Application by Awel y Môr Offshore Wind Farm Limited for an Order Granting Development Consent for the Awel y Môr Offshore Wind Farm project

The Examining Authority's written questions and requests for information (ExQ1) Issued on 27 September 2022

DRAWING NUMBER: 004262401-06
APFF: 5 (2) (1)
Sheet No: 8 of 11

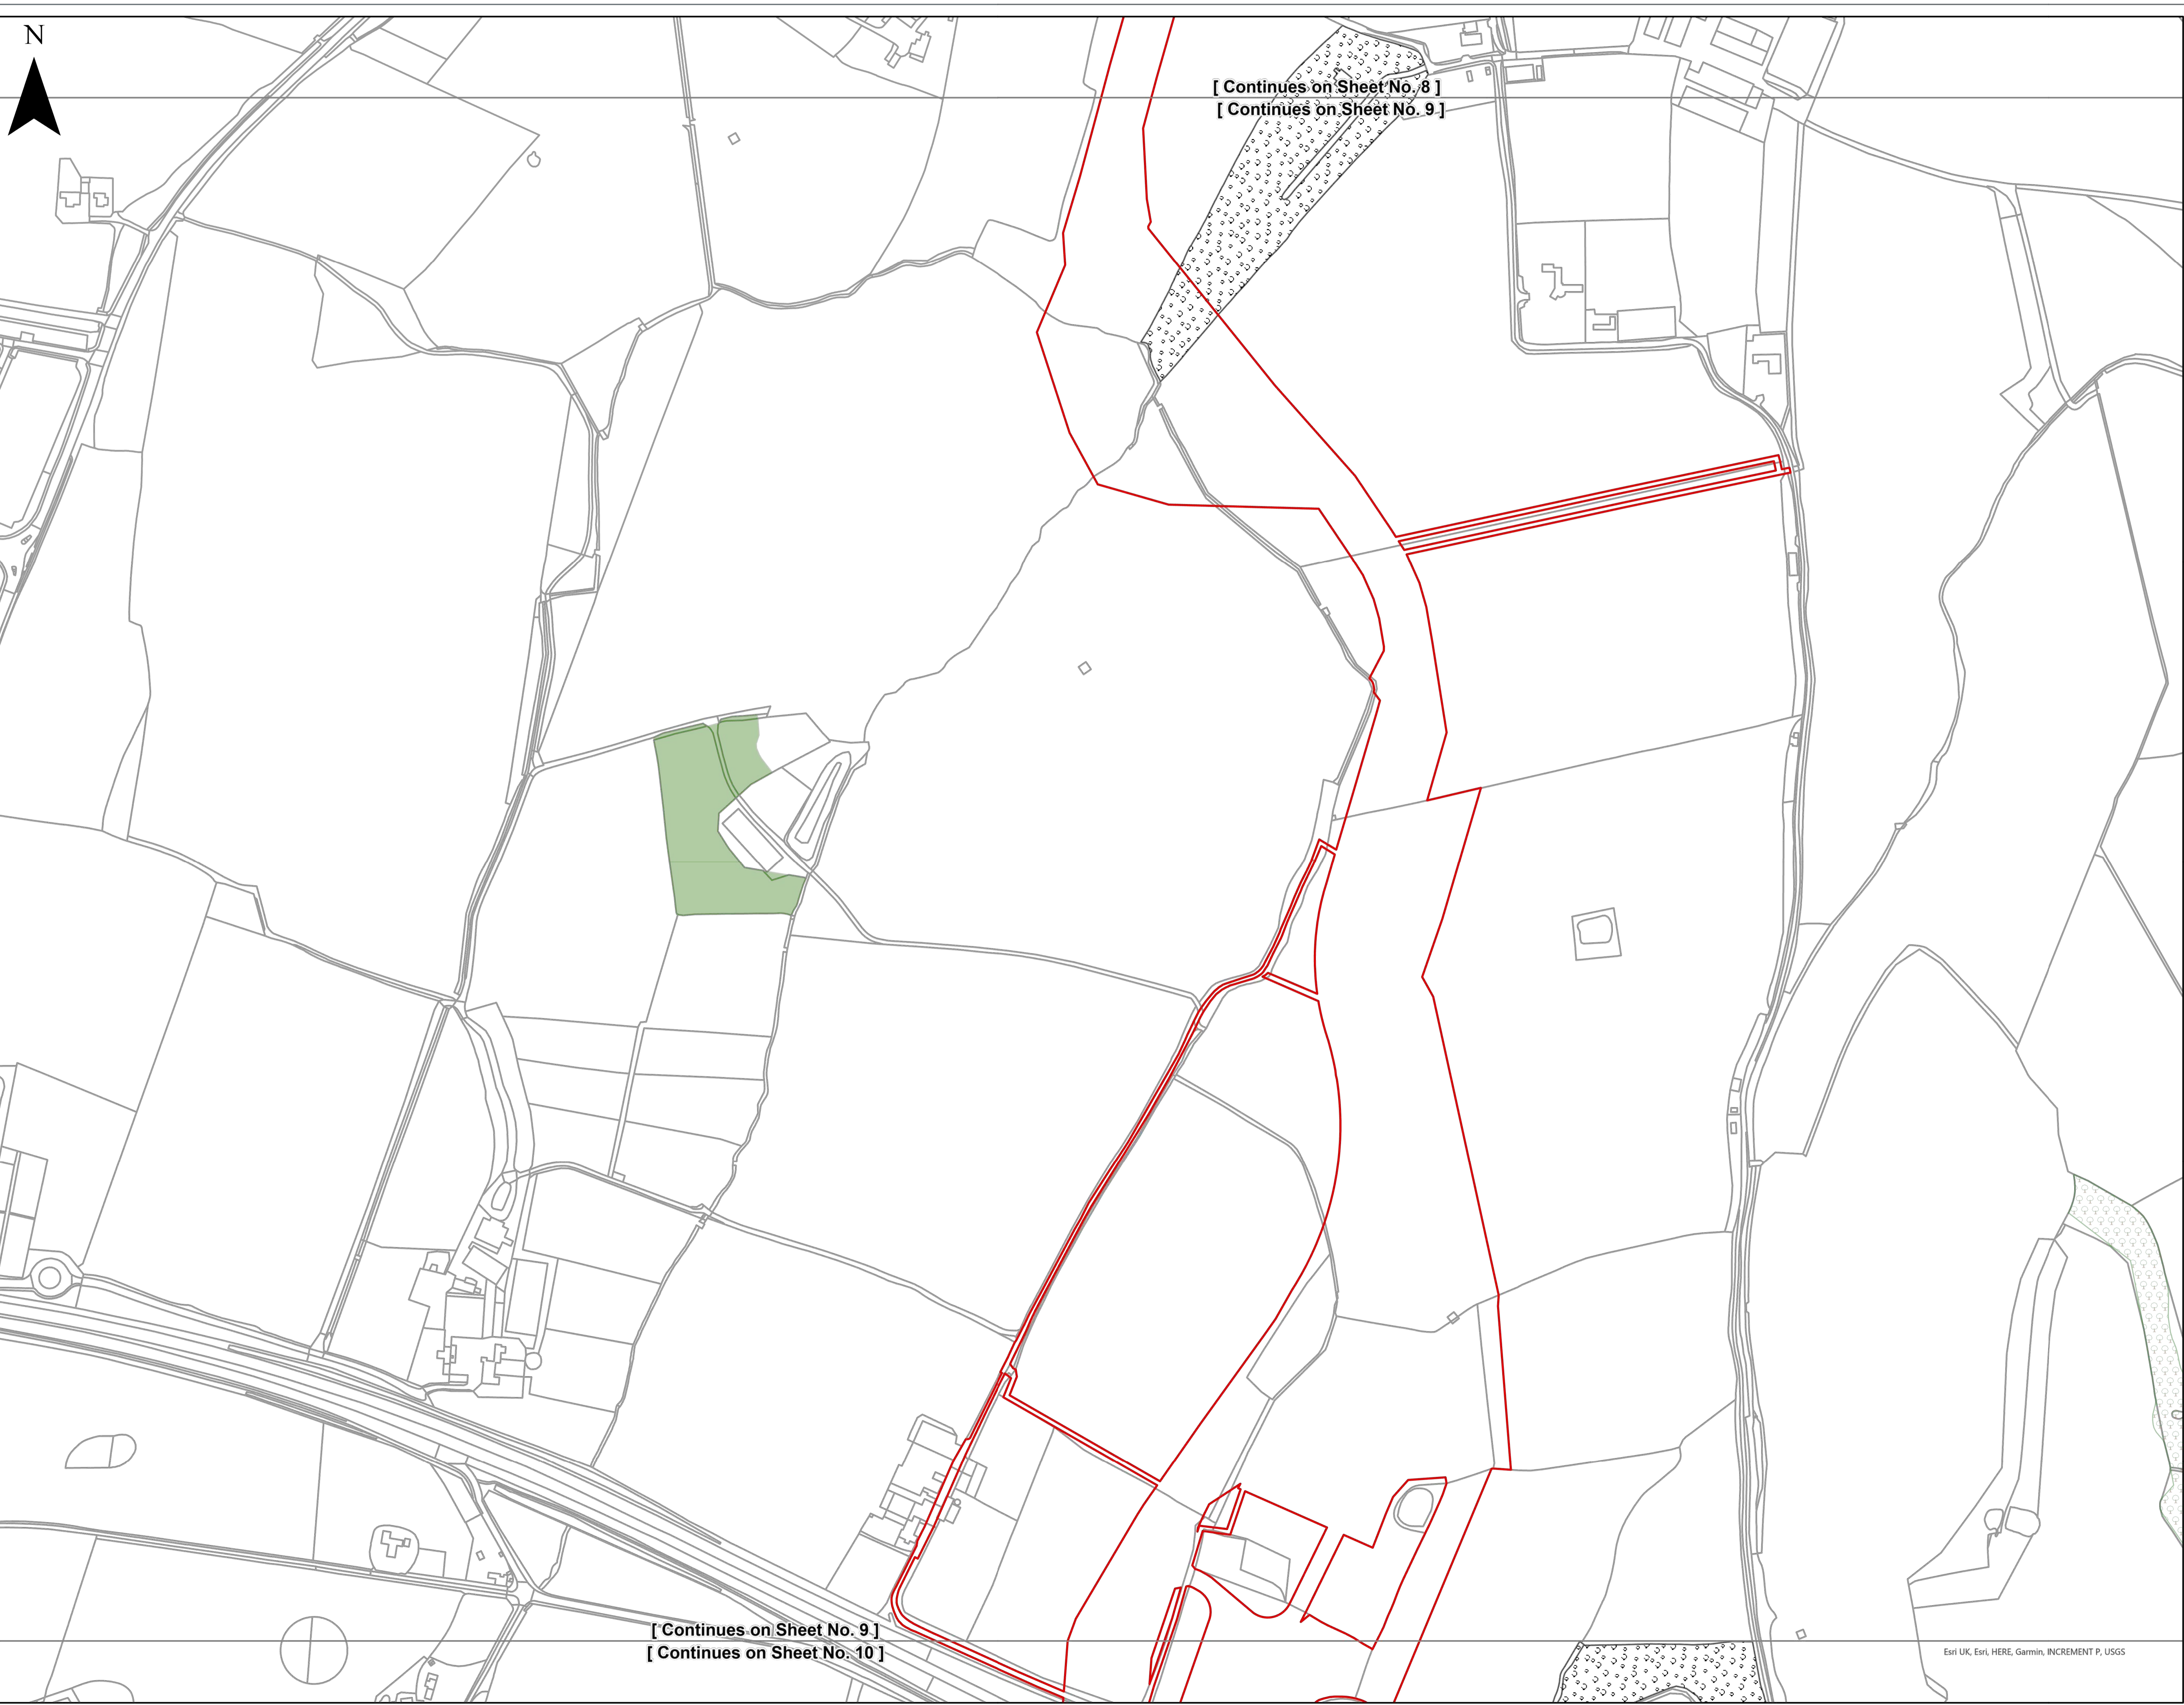
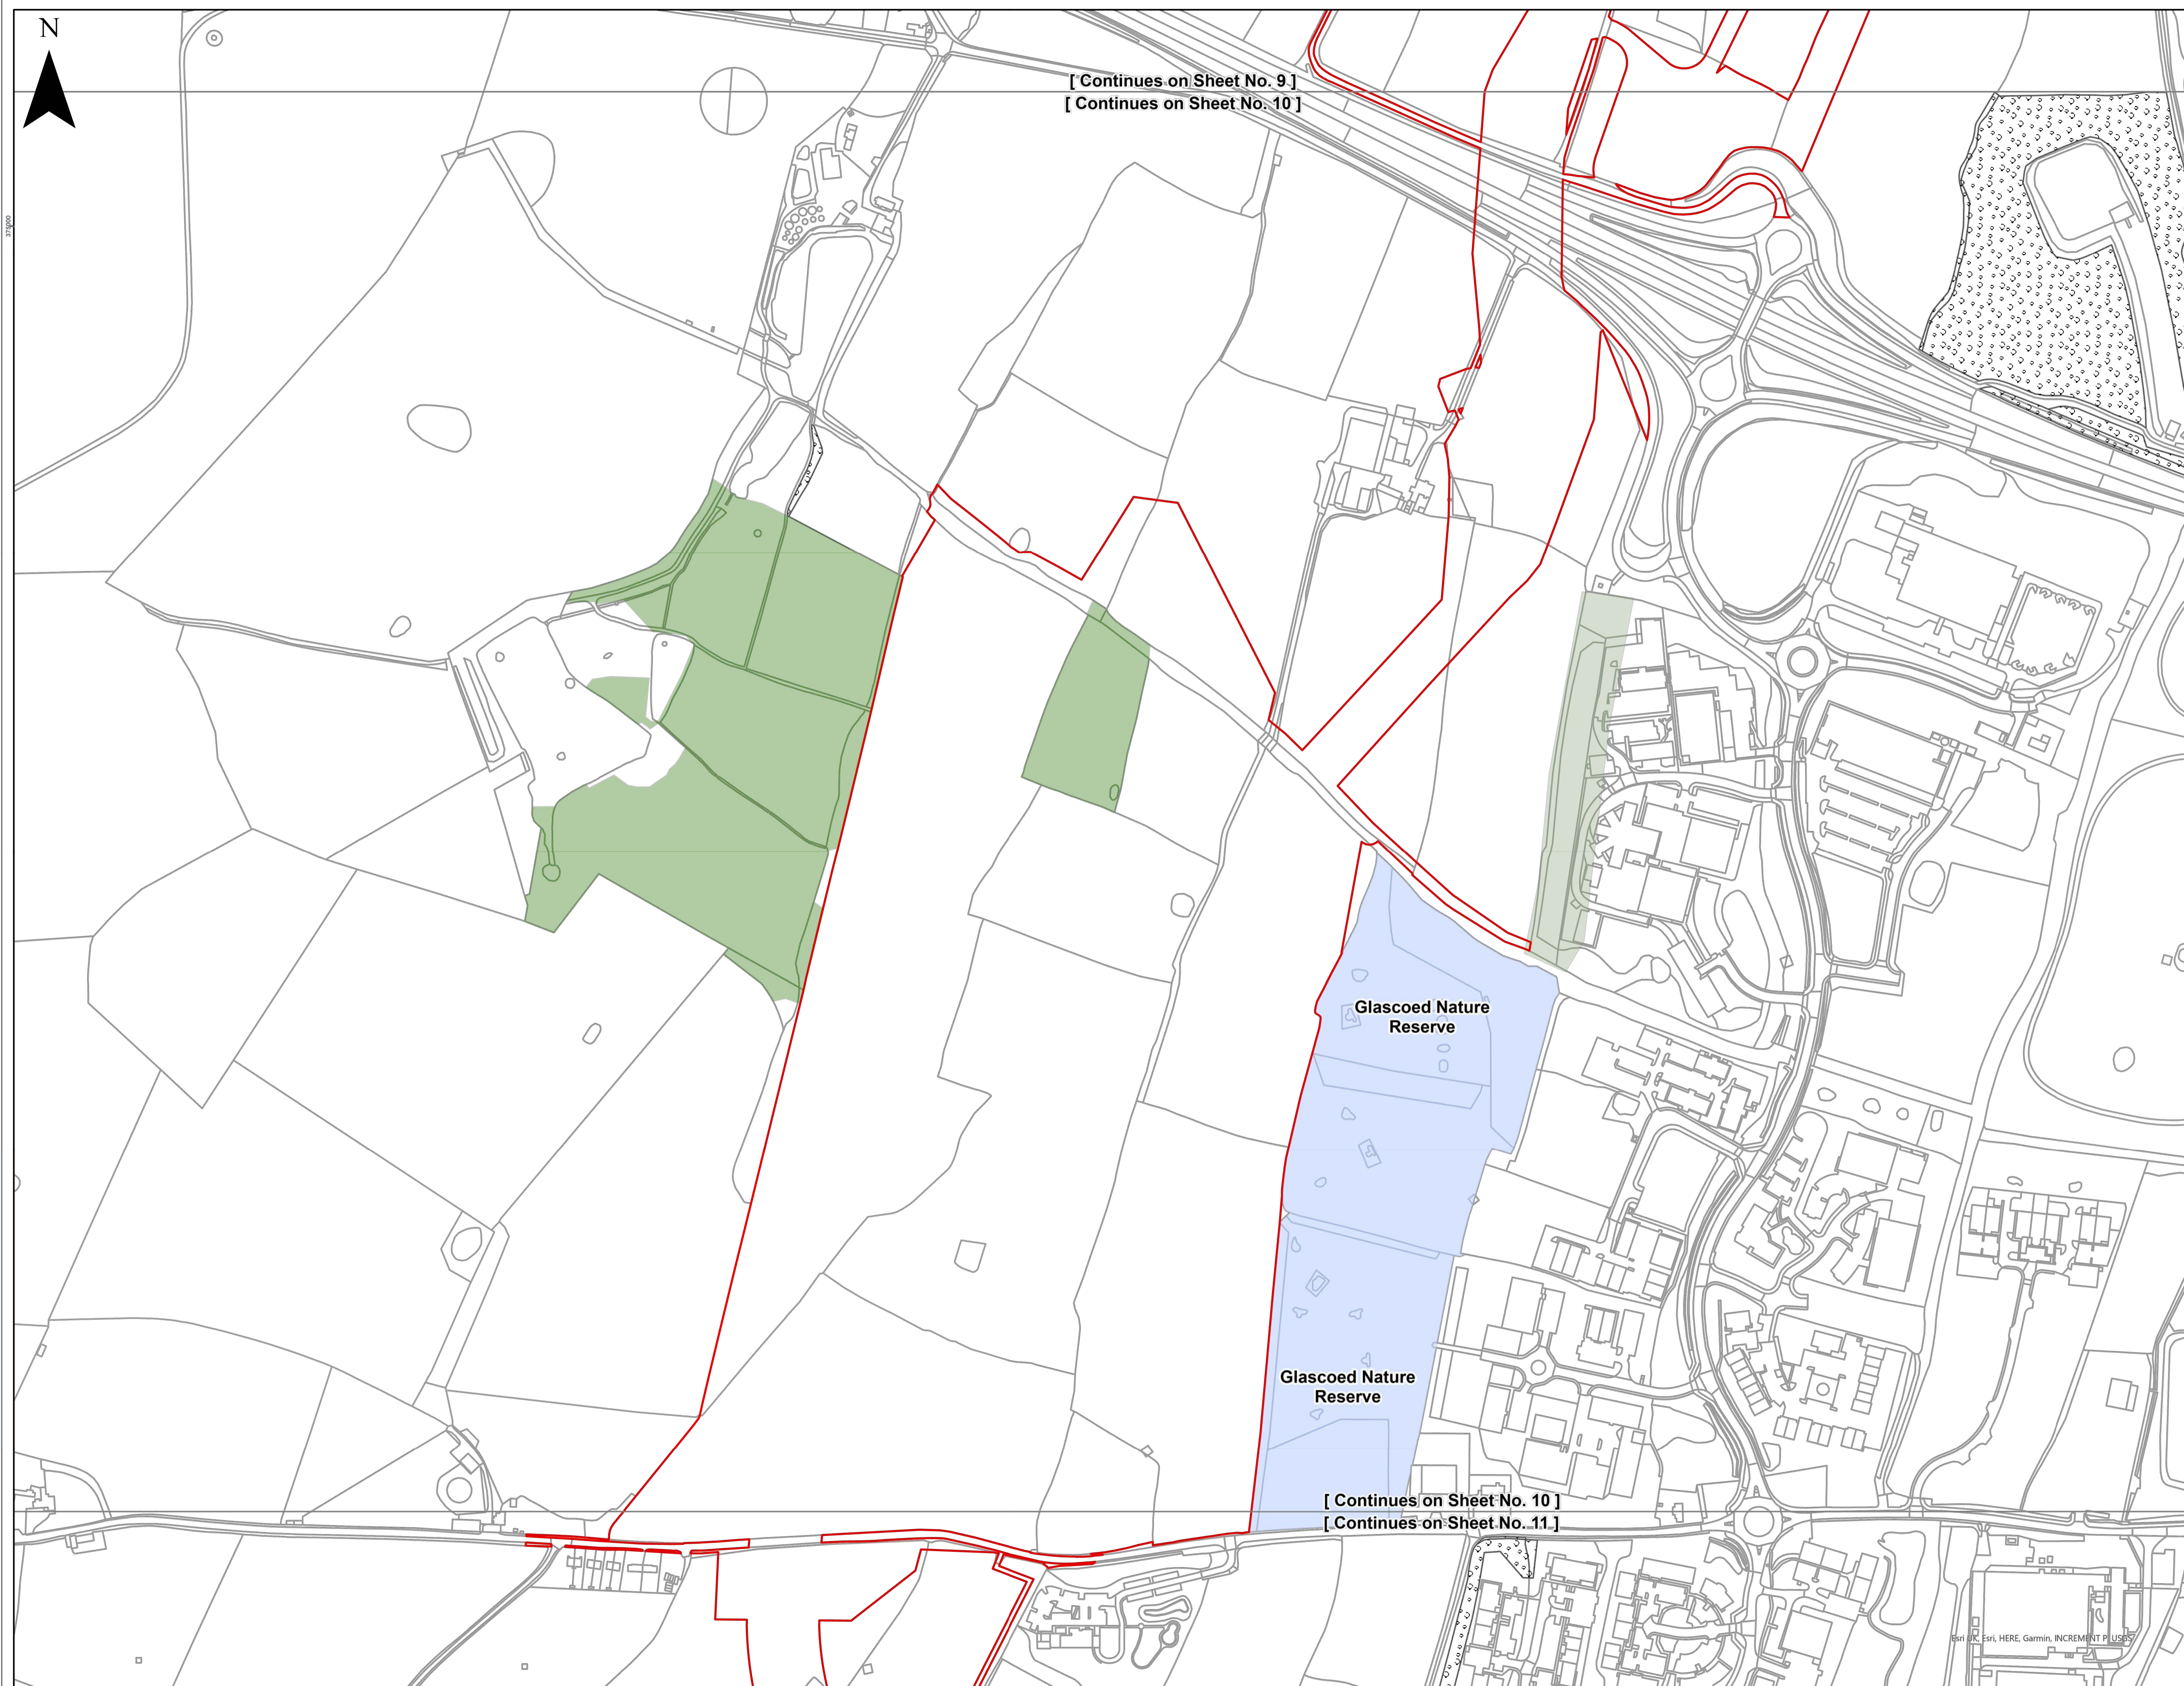
2.7	The Applicant	<p>General Statutory / Non-statutory Nature Conservation Sites Plan [AS-010] Please can you address the following points:</p> <ul style="list-style-type: none">a) Sheet 1 of 11 - The legend does not reflect all hatch colours shown and the extents of SPA hatch appears to be different on sheets 2 and 3;b) Sheet 2 of 11 –does the drawn shape and extent of Local Wildlife Sites at western edge reflects y Ffrith D011;c) differentiate the woodland area to help identify other ancient semi-natural woodland, plantation on ancient woodland site and local other woodland;d) label the name of the other nature reserves on the relevant sheet.
